Consultation Response from KC, Conservation and Design
2021/92462 rear of, 1091, Manchester Road, Linthwaite, Huddersfield, HD7 5LS
Outline application for erection of detached dwelling
Date Responded: 21/09/21
Responding Officer: Craig McHugh
Responding Ref: CV 5/240

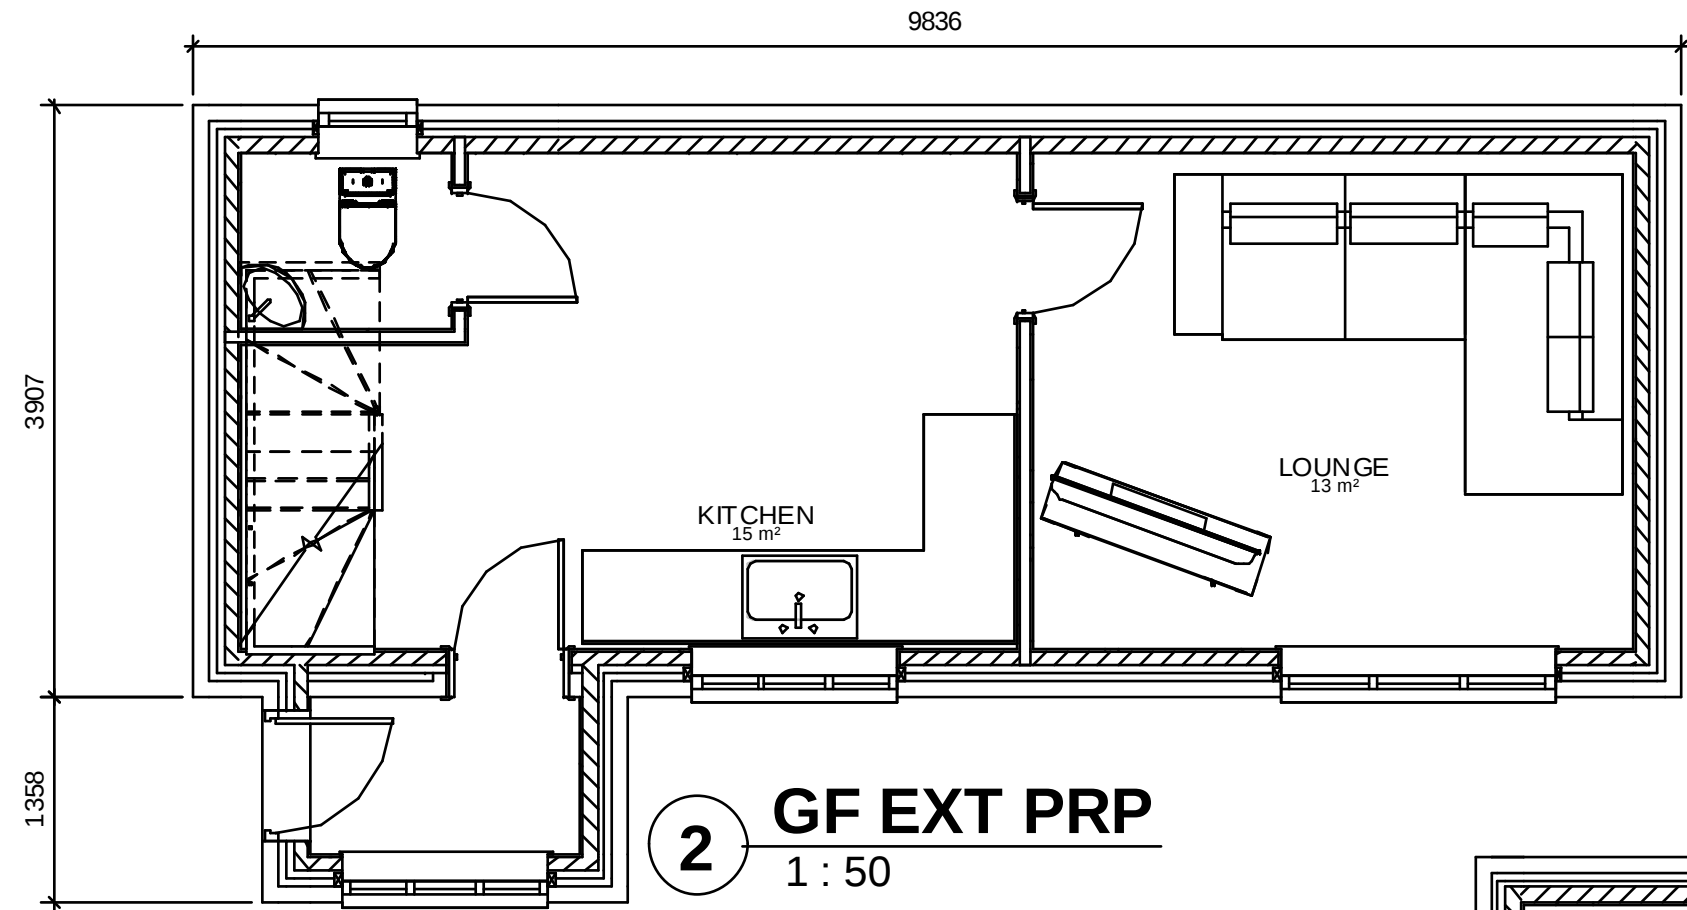
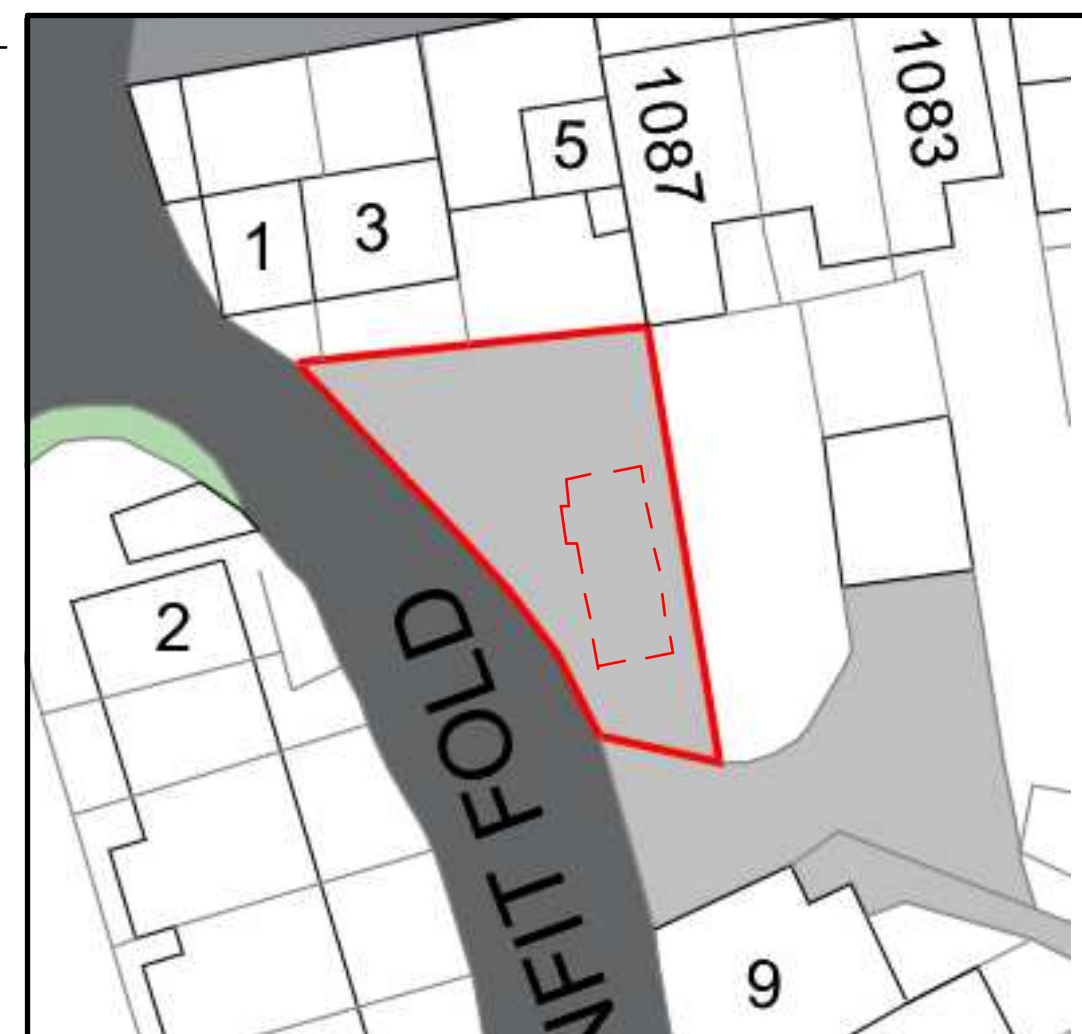
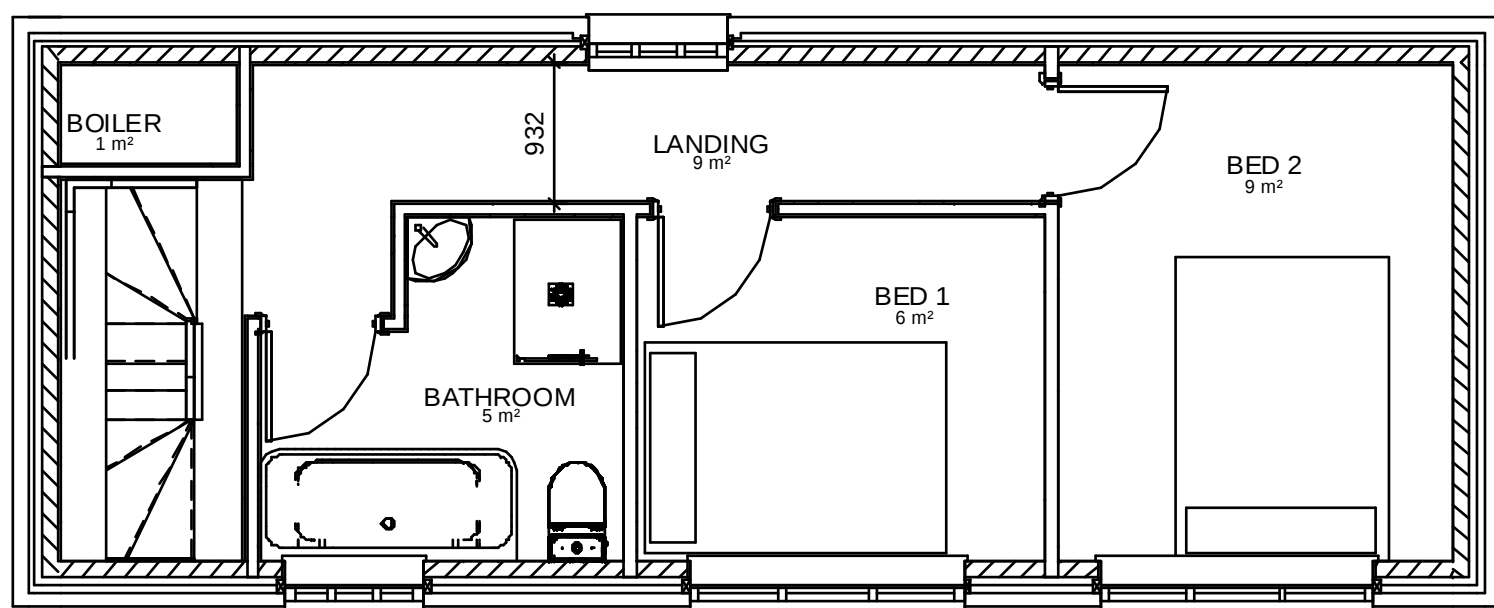
The pattern of development in Linfit Fold is dense but the application site provides an important area of open space contrasting with the built form and creating space across which to view the listed buildings, particularly those to the north. It also has an important role in views down Linfit Road from Linthwaite Hall. Development as proposed would impact on the visual relationship between the Hall and the listed buildings to the north. This area of land has historically remained undeveloped, except for small outbuildings. It therefore has an important role in the setting of the listed buildings, particularly ,3 LINFIT FOLD,1091,1093 MANCHESTER ROAD, 5 LINFIT FOLD,1089 MANCHESTER ROAD and 23,25,27,27A,29 LINTHWAITE HALL, LINFIT FOLD.

Development of the land for housing would cause a high level of harm to the setting of the adjacent listed buildings to the north and a moderate level of harm to the setting of Linthwaite Hall, this would still be less than substantial harm. Any harm is failure in principle since both the Local Plan and the NPPF set out to preserve, protect or enhance heritage assets. It would be contrary to our statutory duties under Section 66(1) and Policy LP35 of the Local Plan. It would also harm the character of the local townscape, contrary to Policy LP24.

Conservation and Design object to the proposed development on heritage grounds. The principle of development of the land for housing would cause a high level of harm to the setting of the adjacent listed buildings to the north and a moderate level of harm to the setting of Linthwaite Hall, this would still be less than substantial harm. Any harm is failure in principle since both the Local Plan and the NPPF set out to preserve, protect or enhance heritage assets. It would be contrary to our statutory duties under Section 66(1) and Policy LP35 of the Local Plan. It would also harm the character of the local townscape, contrary to Policy LP24. The harm has not been justified and the public benefits would be slight.

The application should be refused or withdrawn by the applicant.
